CITY OF ALBUQUERQUE

**Re: Tracts 90A, 90B & 90C MRGCD Map No. 35, Grading & Drainage Plan
Engineer's Stamp dated 6-27-05 (H13-D49)**

The following is written in response to your comments dated June 08, 2005. The responses are in the same order as the comments.

sheet title
GRADING & DRAINAGE PLAN

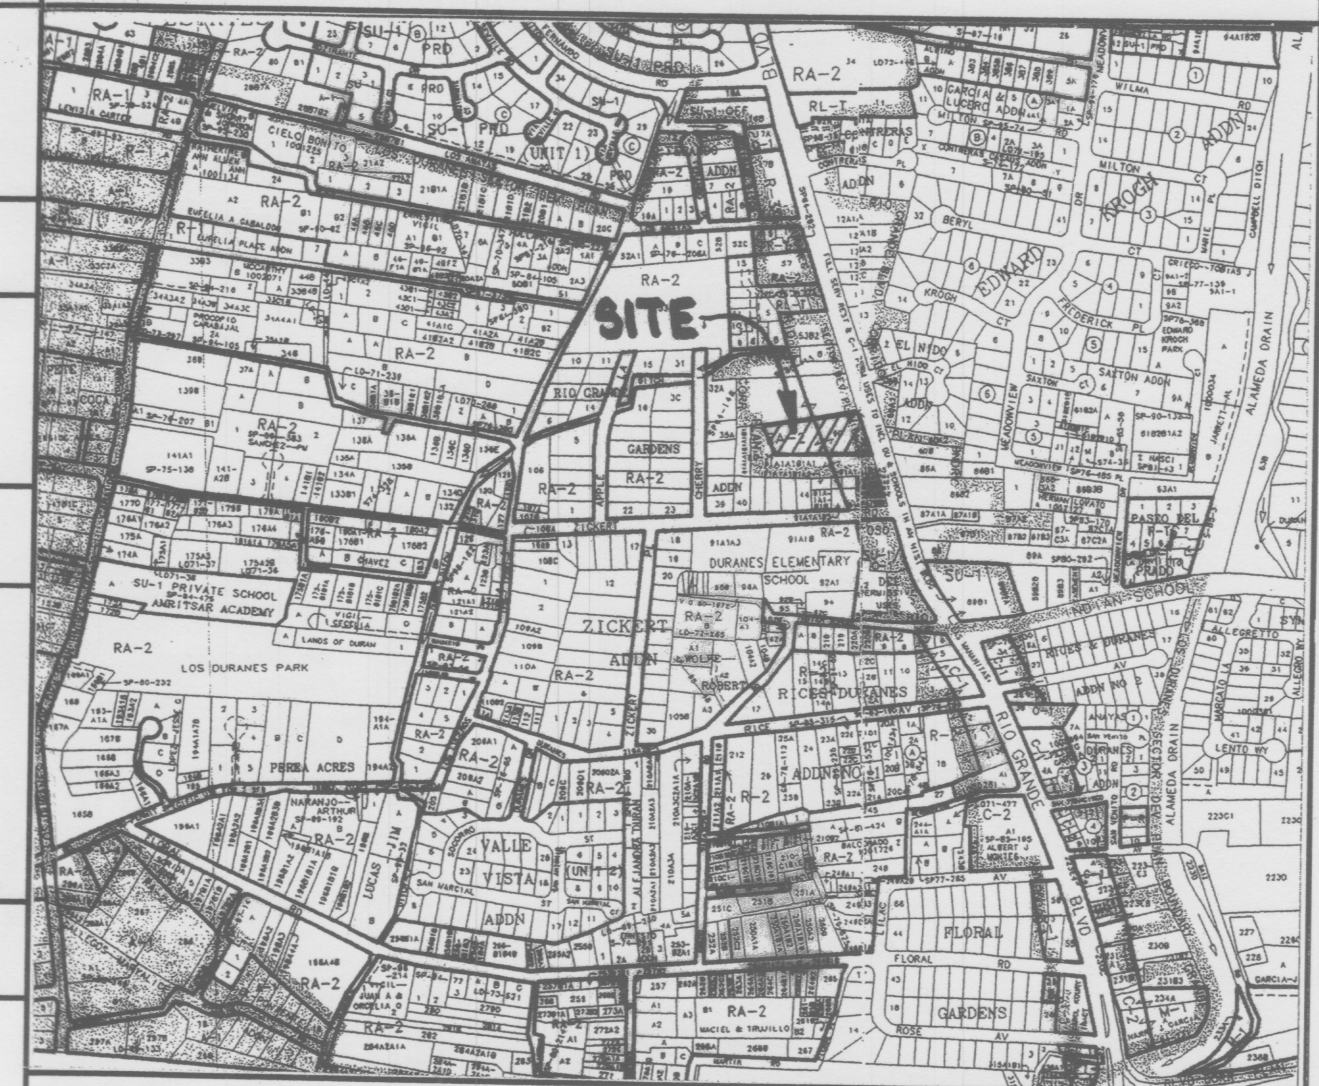
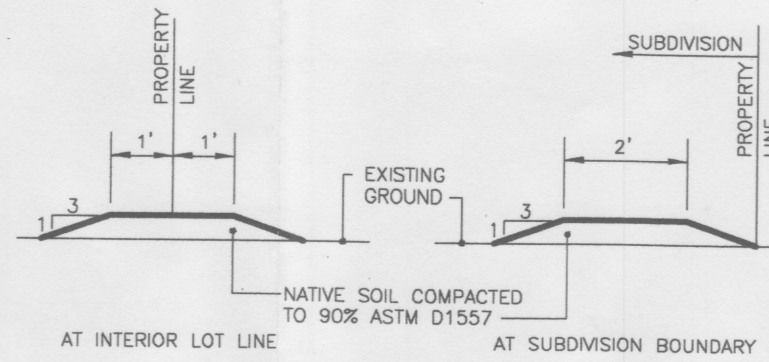
- Verify that the maximum percent impervious of the maximum pad size allowed and the contributing area is not greater than 45 percent.
- Provide a permanent wall (CMU or concrete) around lots 90-B and 90-C capable of containing the 100 year 24 hour storm developed runoff (minimum height = 1'-0").
- Show the 100 year 10 day water surface elevation on plan.
- Verify that the pad elevation is a minimum of 1'-0" above the 100 year 10 day water surface elevation.
- Verify that there is no accessible storm drain near the proposed site.

1. A blanket drainage easement will be created on the largest of the three parcels to accept any pond overflow from the smaller parcels. Therefore, limiting impervious surface on the smaller parcels is not of concern.

2. Again, a blanket drainage easement will be created on the largest parcel and is to accept excess runoff from the smaller parcels. Therefore, it is requested that the proposed earth berms be accepted.

3. An approximation of the 100 year, 10 day pond water surface has been added to the plan.

4. The residence's floors on the smaller lots are more than one foot above their respective berms and therefore more than one foot above the ponded water surface of the 100 year, 10 day storm.

5. There is an existing storm drain in Rio Grande Blvd. and a catch basin on the west side of the street north of the northeast corner of the site. It is requested that the construction of storm drain facilities be deferred until the larger parcel is subdivided into several smaller lots.
